# CITY OF ALBUQUERQUE

August 24, 2017

**Re: Dominos, 2505 San Mateo Blvd NE**  
**Project Address**  
**Traffic Circulation Layout**  
Architect's Stamp 08-14-17 (H17D113)

NEW WORK SITE PLAN 2  
1" = 20'

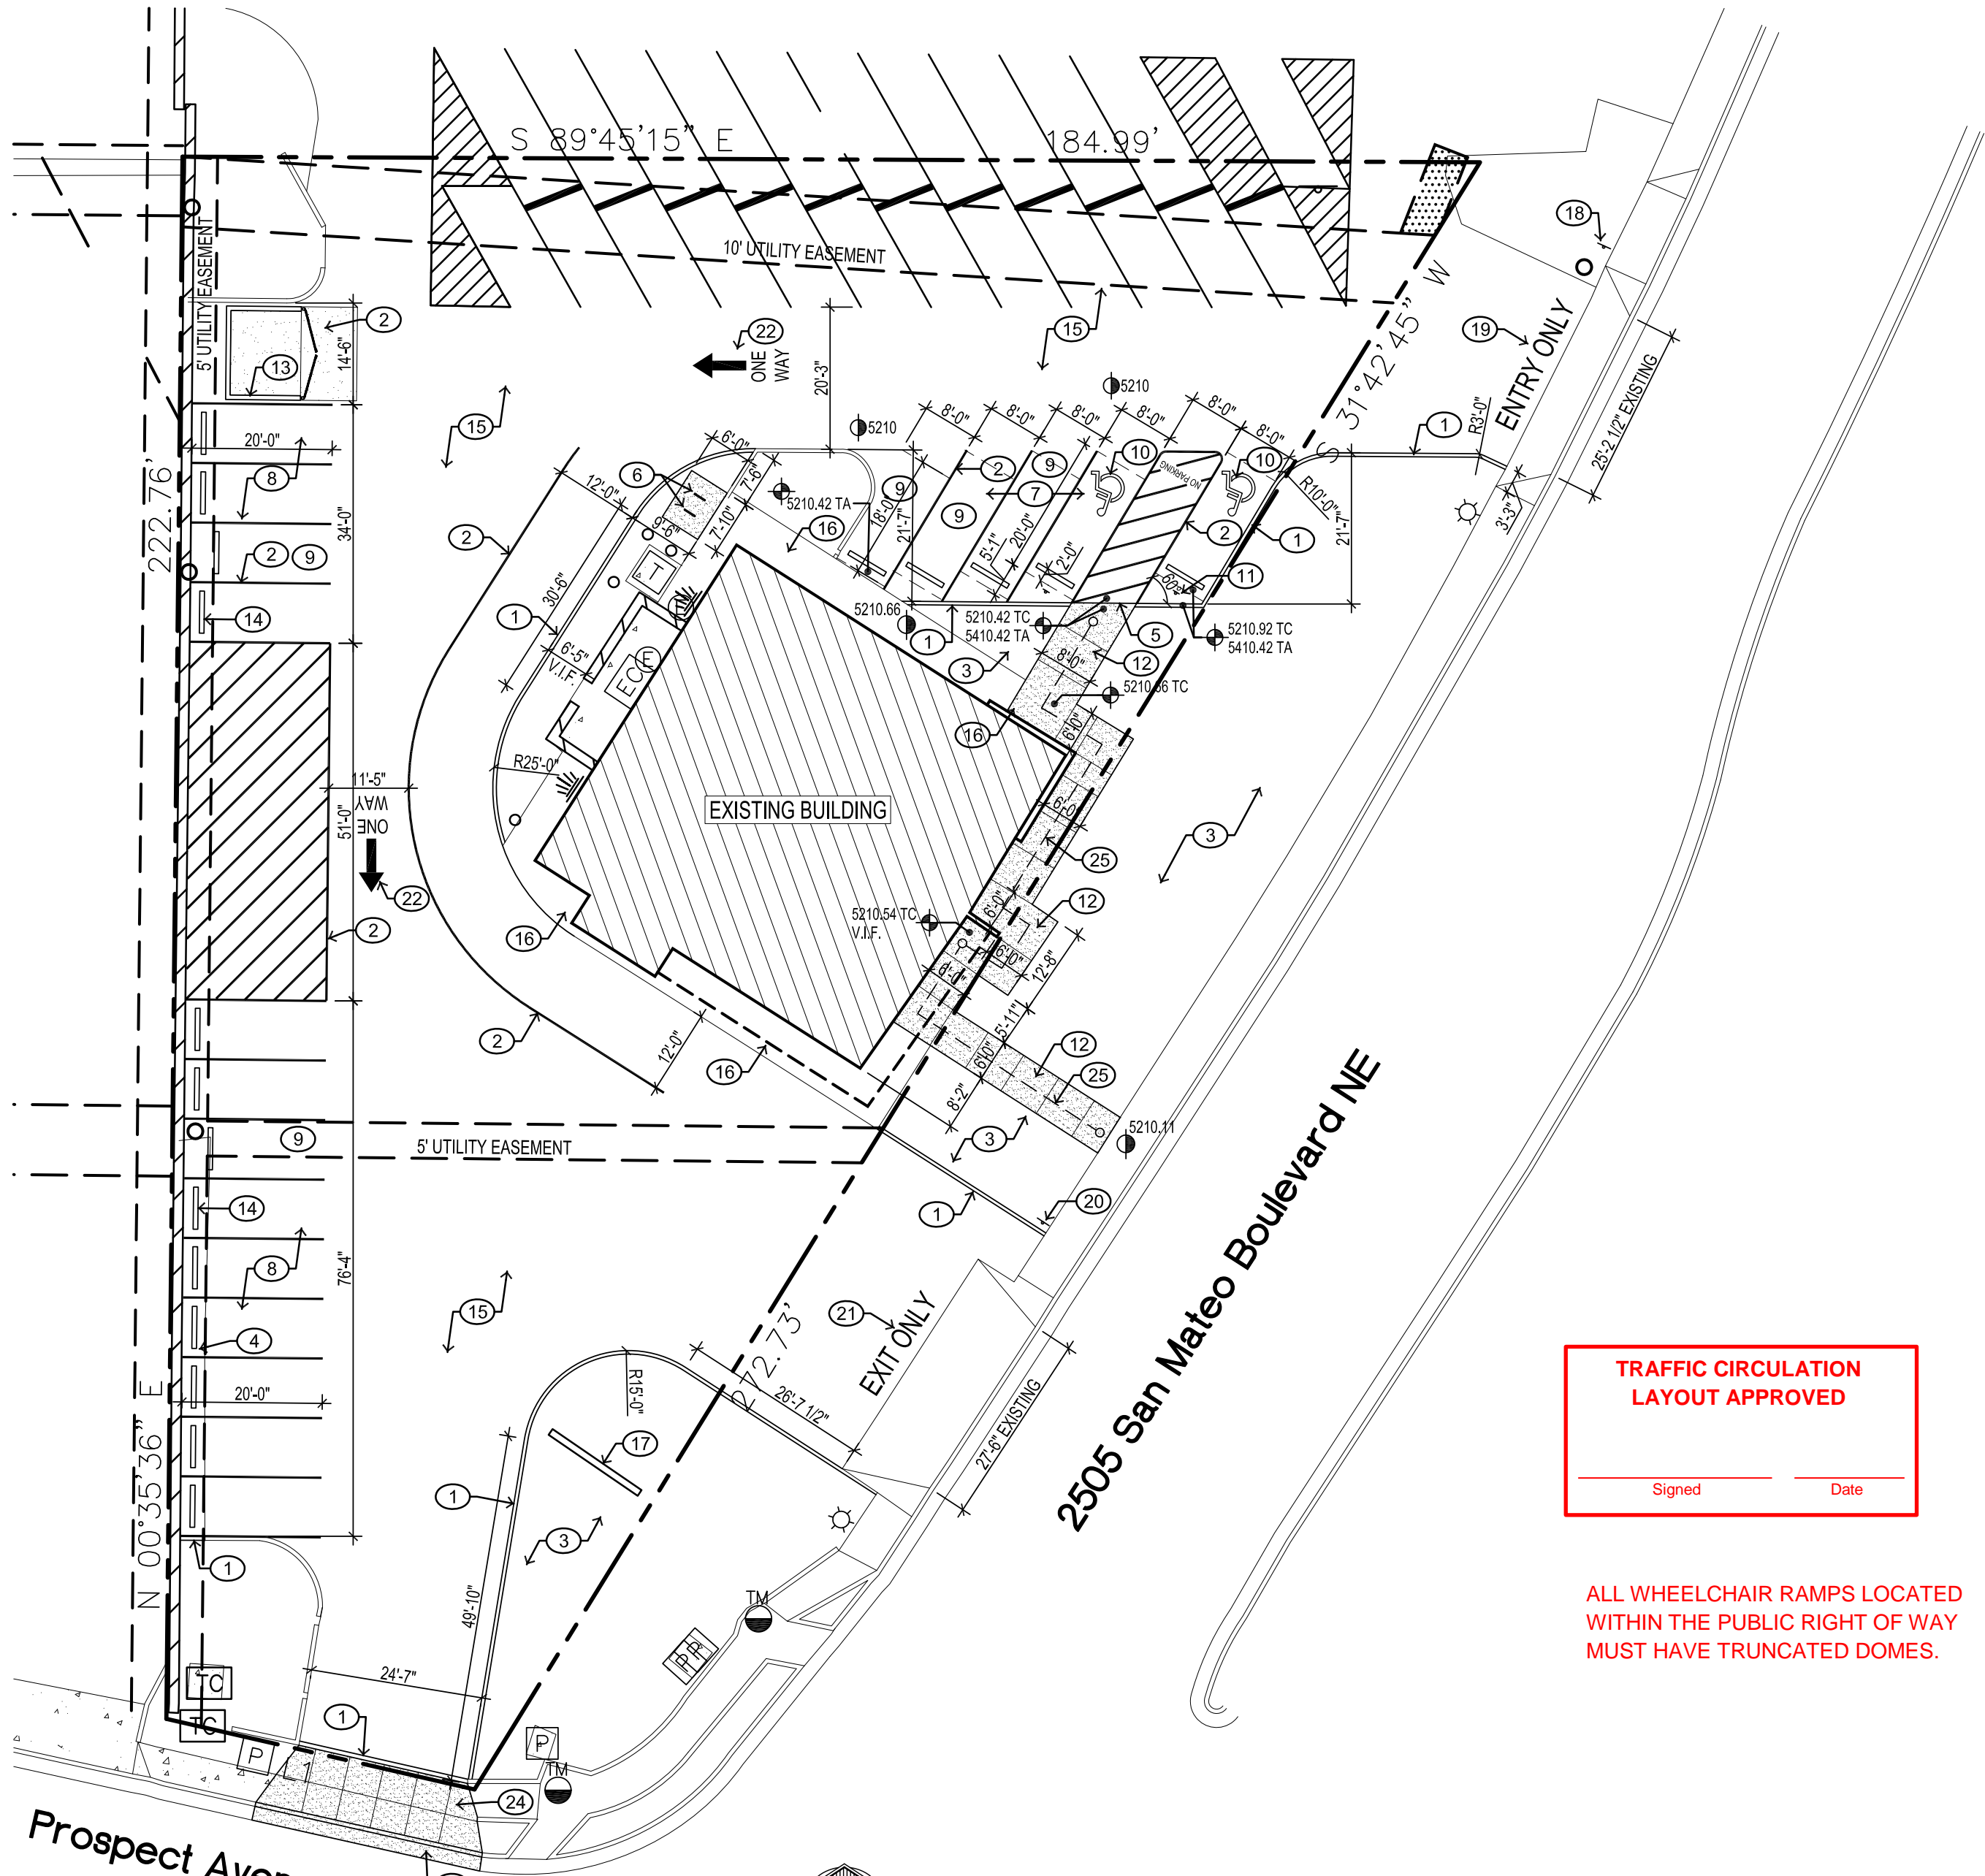
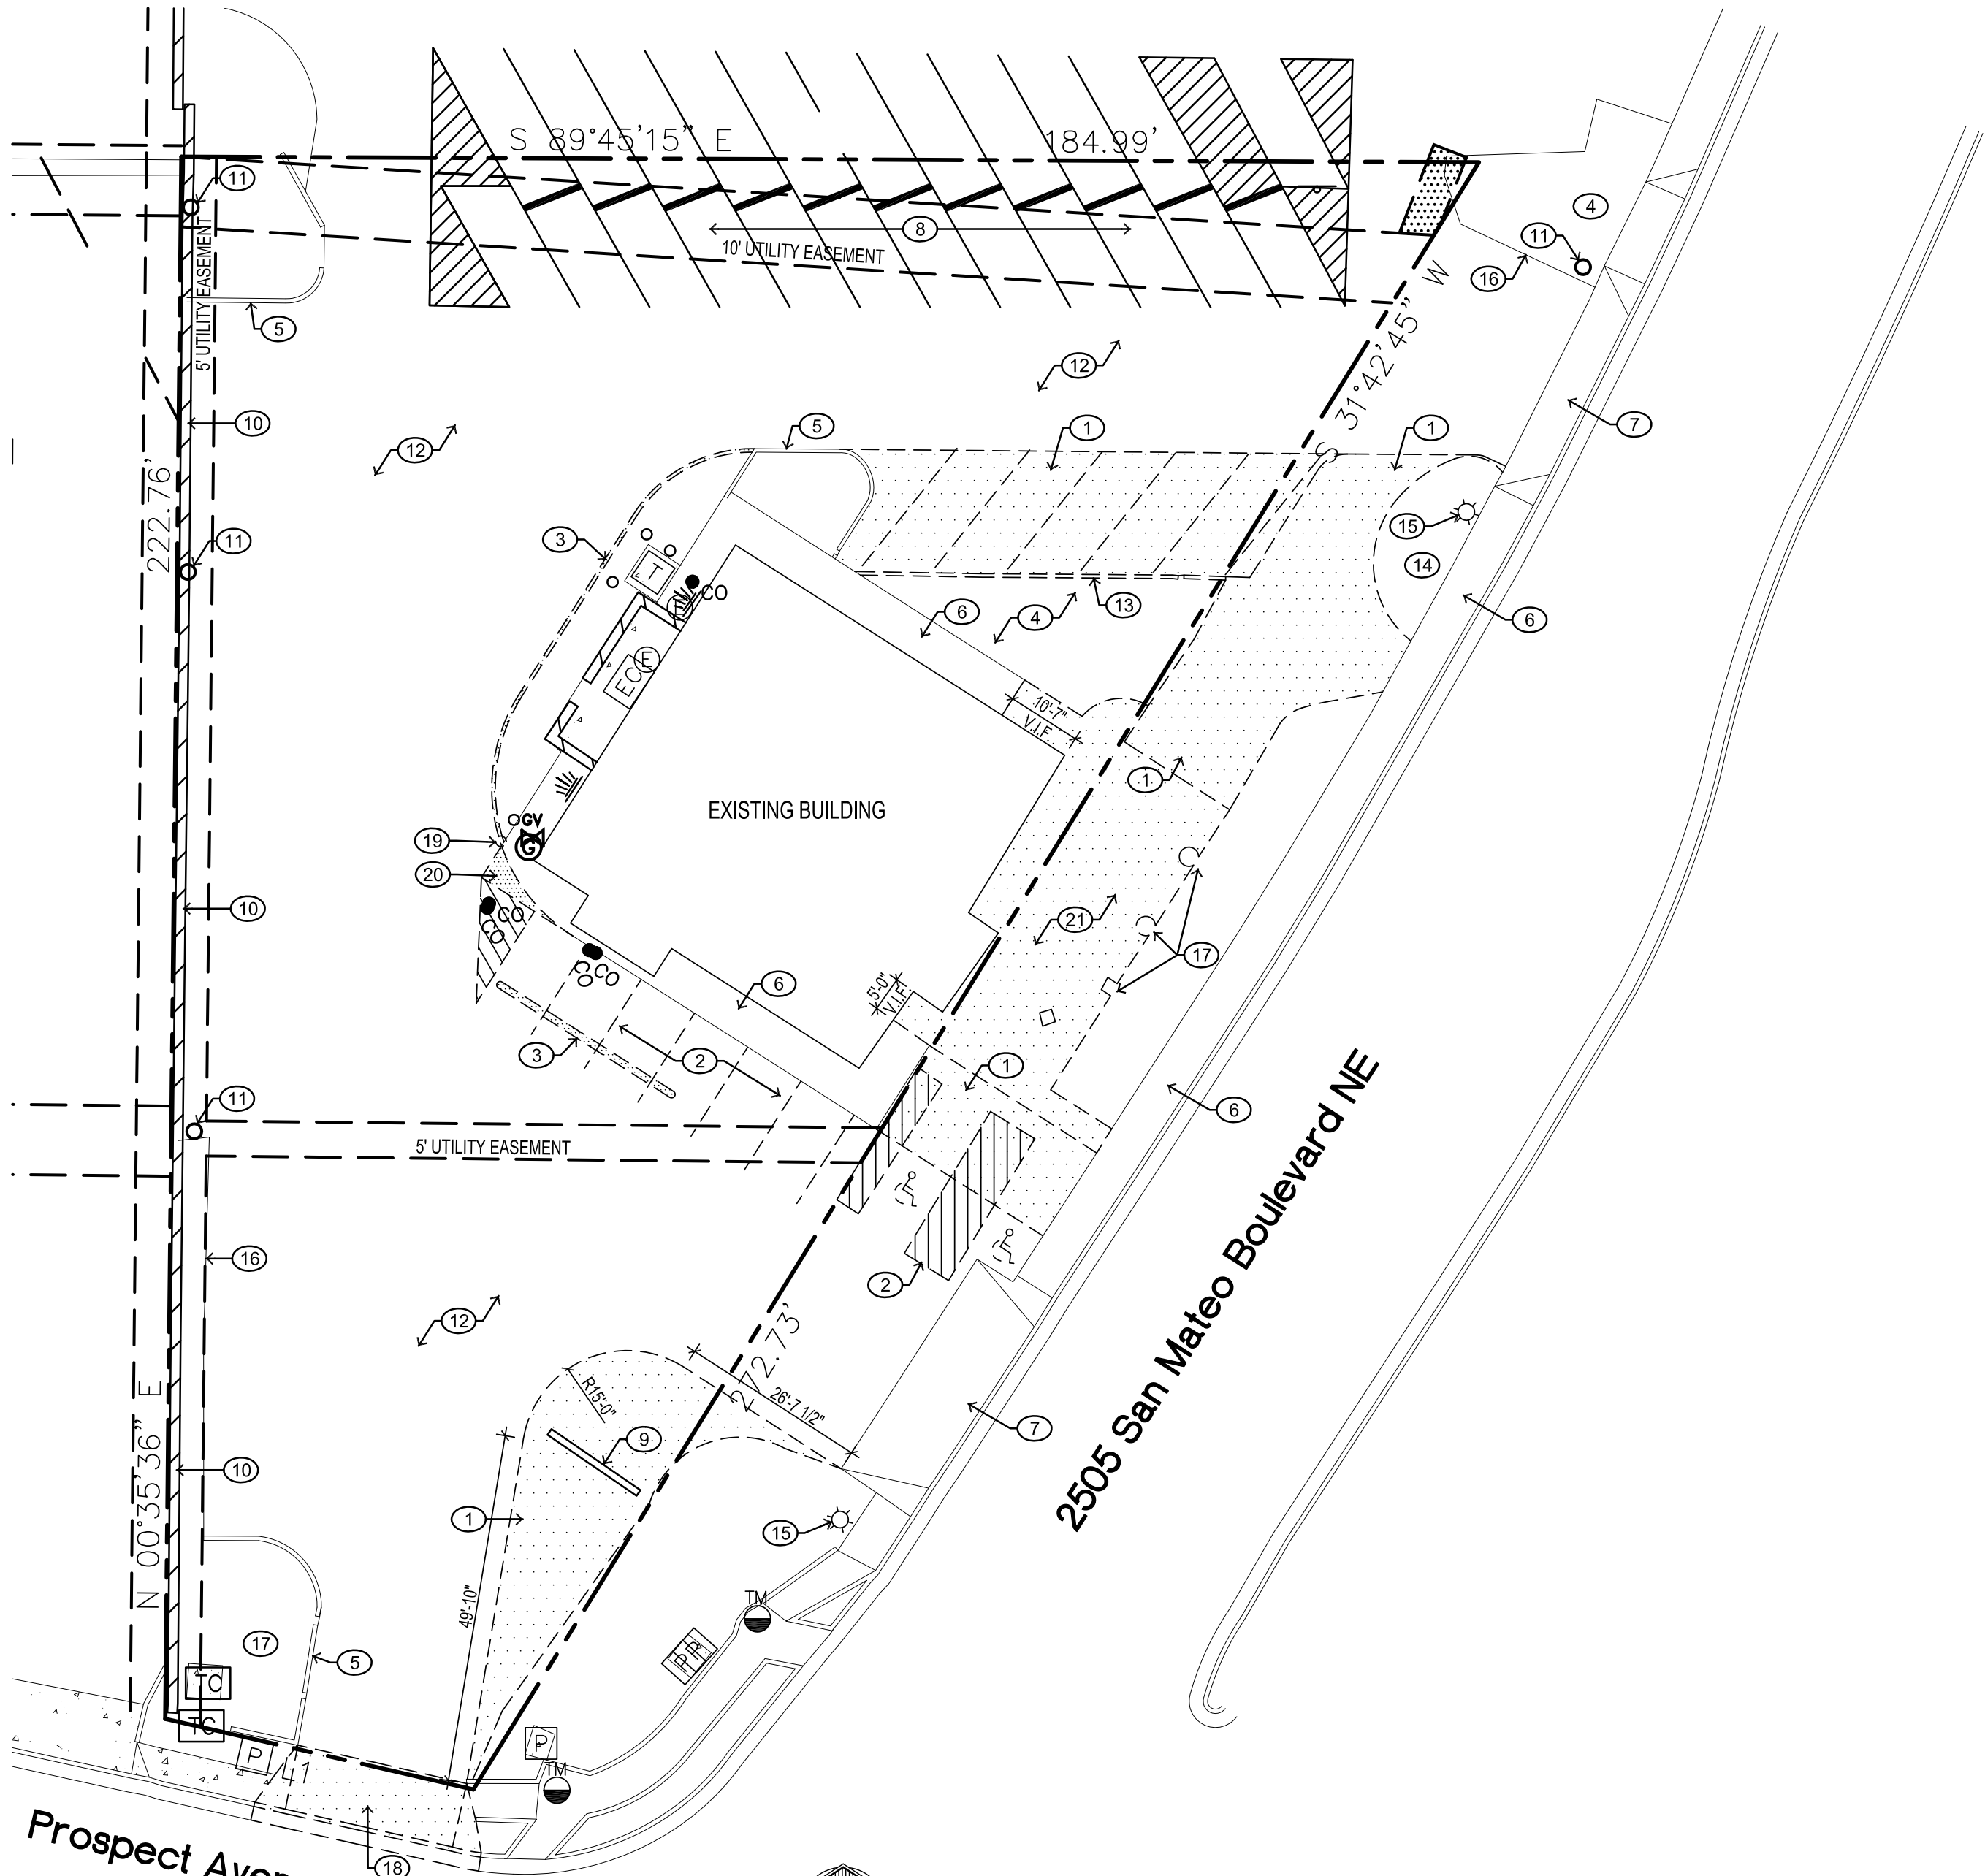
1. Per the zoning code, a 6 ft. wide ADA accessible pedestrian pathway is required from the public sidewalk to the building entrances. Please clearly show this pathway and provide details.
2. Per DPM, ADA accessible pedestrian pathway is required from the HC parking stall access aisles to the building entrances. Please clearly show this pathway and provide details of ramp.
3. Please include a copy of your shared access agreement with the adjacent property owner.
4. Prior to approval and release of Certificate of Occupancy a revocable permit must be submitted and approved for the bike rack and concrete area located within the City of Albuquerque right of way.
